18/00825/HYBRID

Heyford Park, Camp Road, Upper Heyford

A hybrid planning application consisting of:

POS LAND USE PLAN

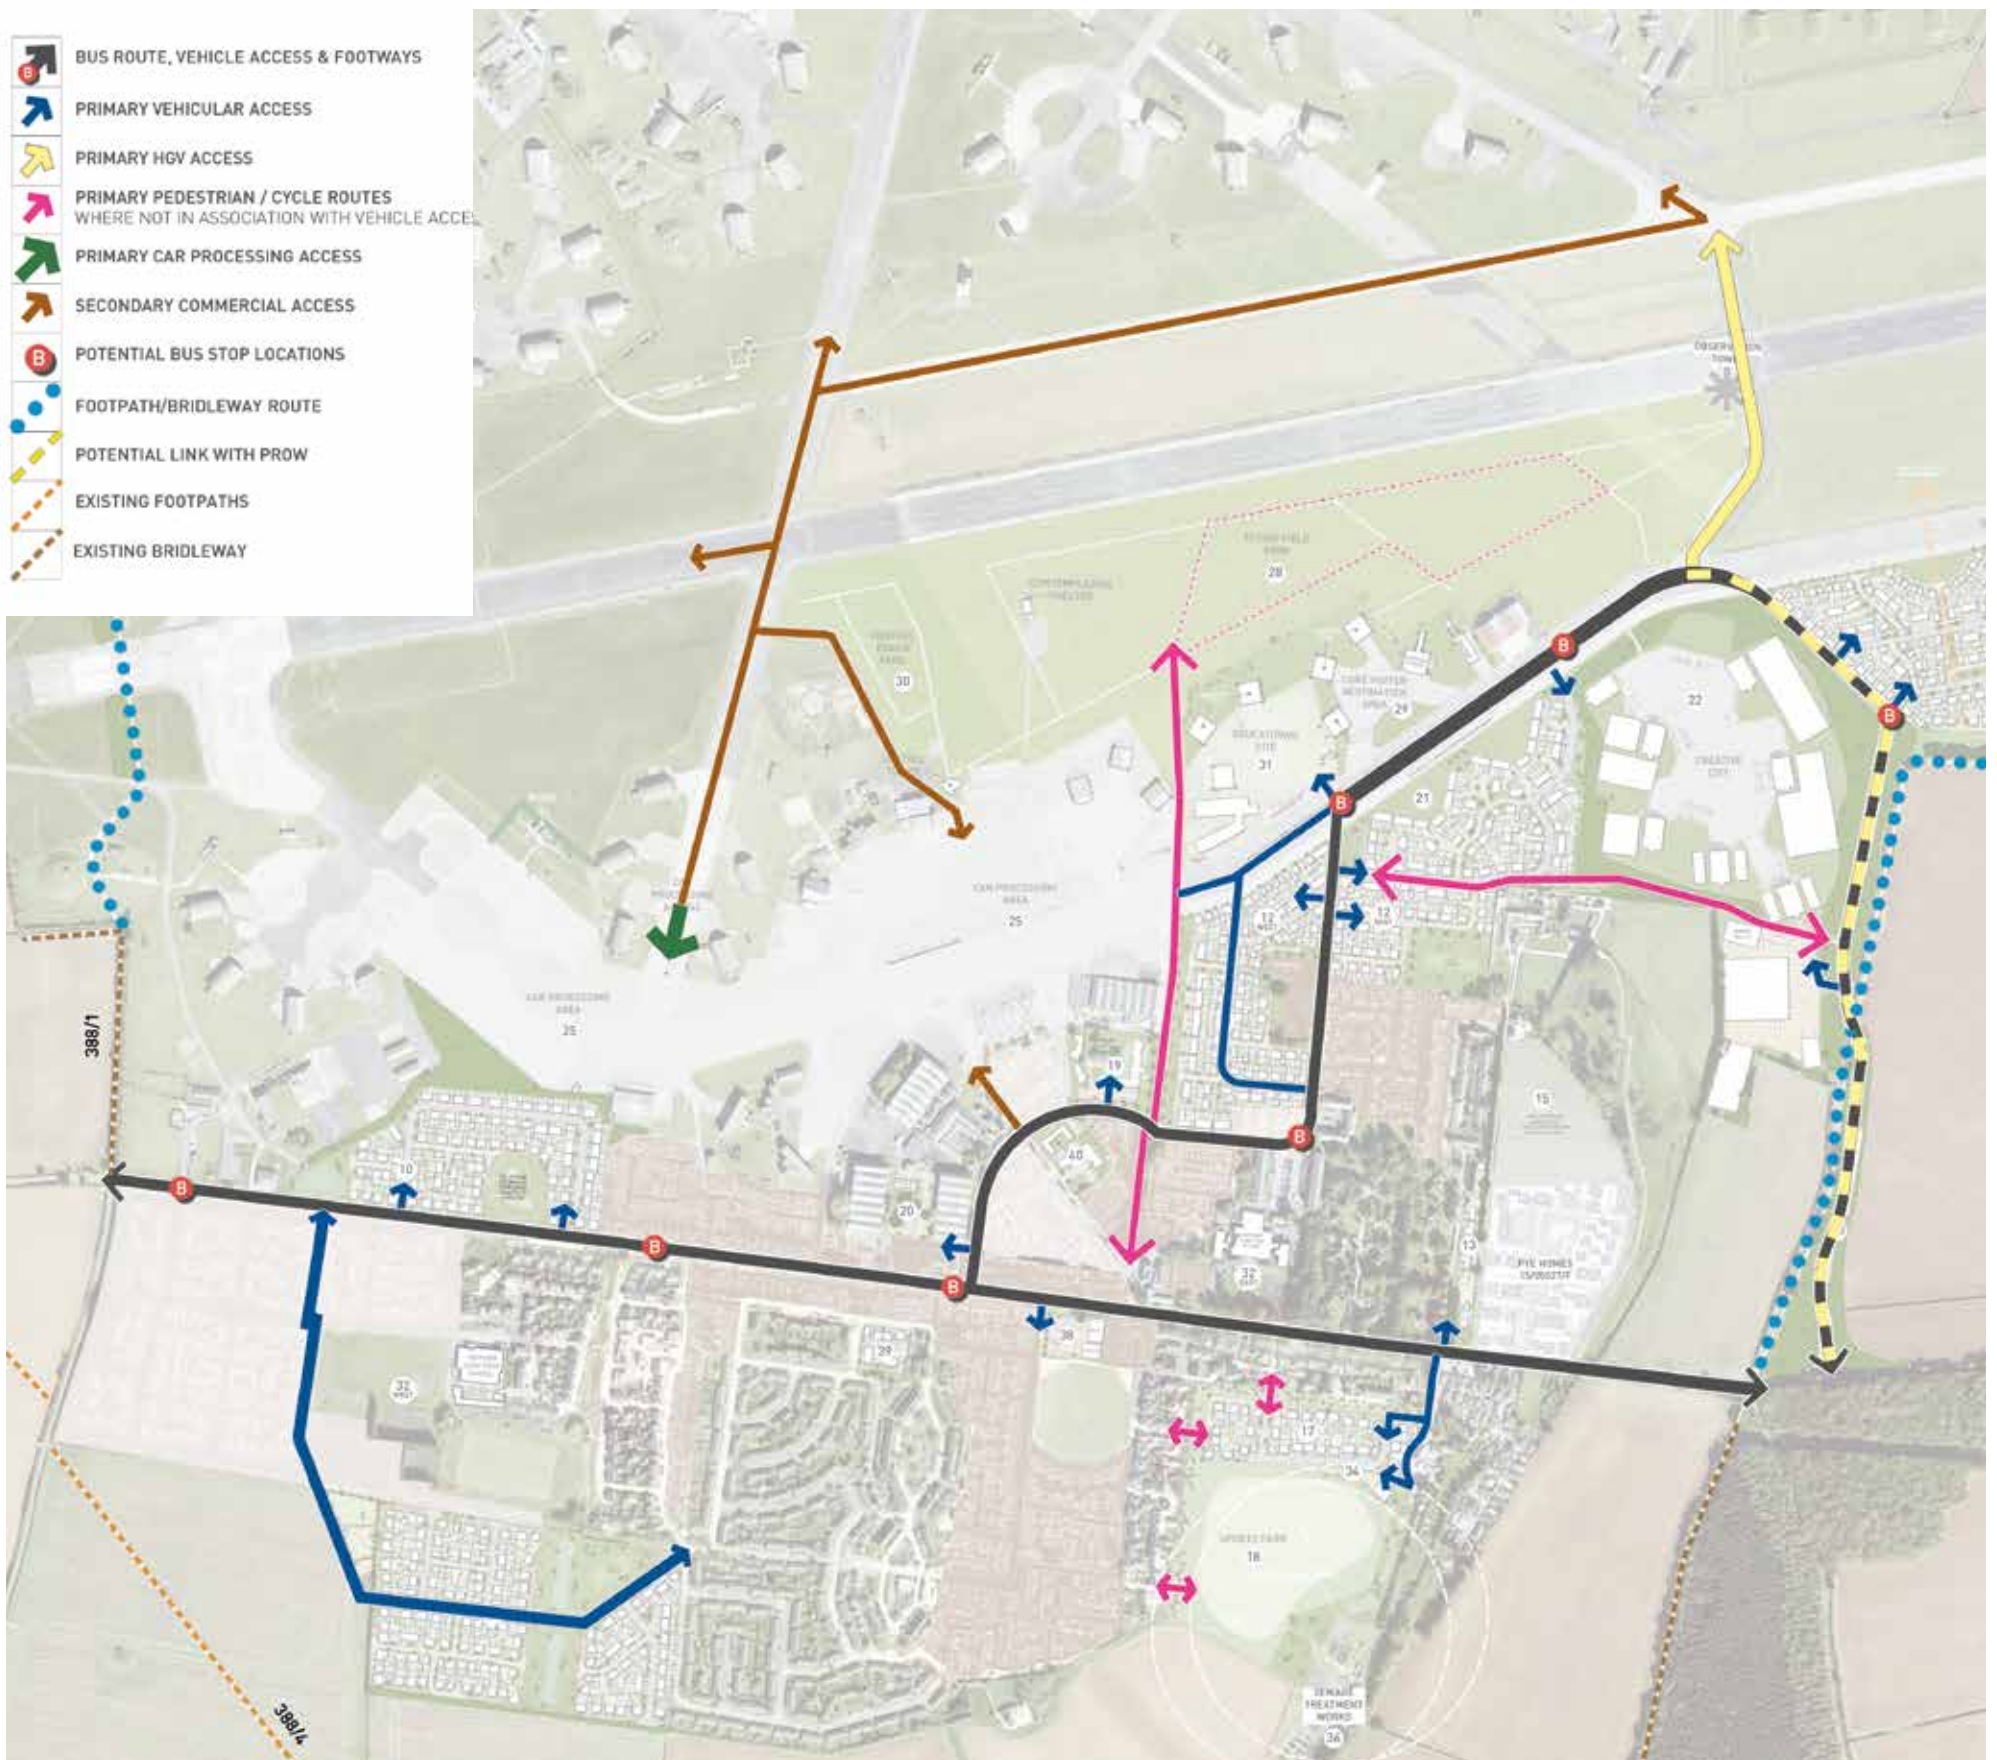
The Design and Access Statements claims that '*The park will be an informal landscape and include a range of amenities and facilities for casual and informal use by visitor and the parkland and commercial community*'. The landscaping details are of fundamental concern and details will need to be submitted at an early stage of any reserved matters application. The **public benefit** of access to the airfield could be outweighed by **harm** if the landscaping details are inappropriate for the context. Particular attention should be paid to the relationship with other areas of the site and any associated boundary features.

There are concerns with the proposed 'Observation Tower' which it is noted will be up to 30m in height. This will potentially have an impact on surrounding heritage assets (including Rousham Park) as well as the airfield itself. The original proposal was to have the tower on the runway itself, but following comment during the pre-application process it has been moved slightly to the south of the runway, but is still considered to be in too close proximity and will cause harm to the understanding of the function and layout of the airfield runway. Further information will be required at reserved matters stage on the design of the tower. It is understood that a survey has been undertaken assessing the impact on the surrounding area of the proposed tower at different heights – this should be utilised to inform the design and height of the tower and should be included as part of any forthcoming application. Part of the justification for the proposed observation tower is that it will bring additional tourism to the area and will provide greater access to the parks – this will need to be demonstrated and justified within any forthcoming reserved matters application.

Z12 – Creative City

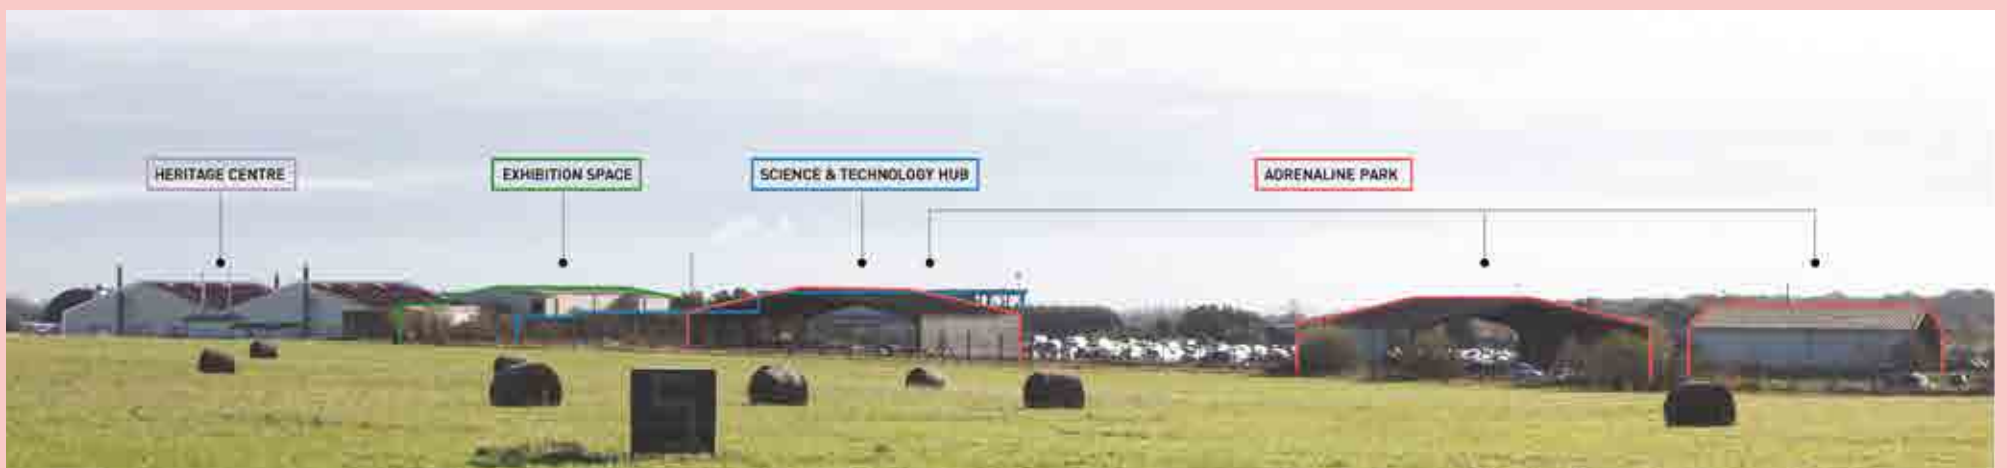
The proposal to find a new use for the Hardened Aircraft Shelters for the 79th Squadron around the 'Christmas Tree' to the south west of the site was generally welcomed at pre-application stage. The proposal to adapt the structures for use by high tech creative industries was supported. It was considered that there would be a **public benefit** to finding a sustainable new use for these buildings. It was understood that there would be a need for some extension to these buildings in order to make them viable for use.

It is appreciated that the buildings will remain and that in the proposed arrangement the central space would be retained. The proposed footprint of the extensions to the buildings outlined within the application, however, suggest a scale that will completely dwarf the existing buildings and will cause **substantial harm** to the setting of the buildings. It is appreciated that there has been a slight reduction in buildings heights for the proposed new build in this location, but this is not considered sufficient to mitigate concerns. The proposed footprint and massing of the proposed extensions are still considered excessive and will have a detrimental impact on the original buildings and the setting of the flying field. The application for extensions of this scale cannot be supported from a conservation perspective. It should be noted that the principle of conversion and extension is potentially acceptable subject to amended and further detailed plans.
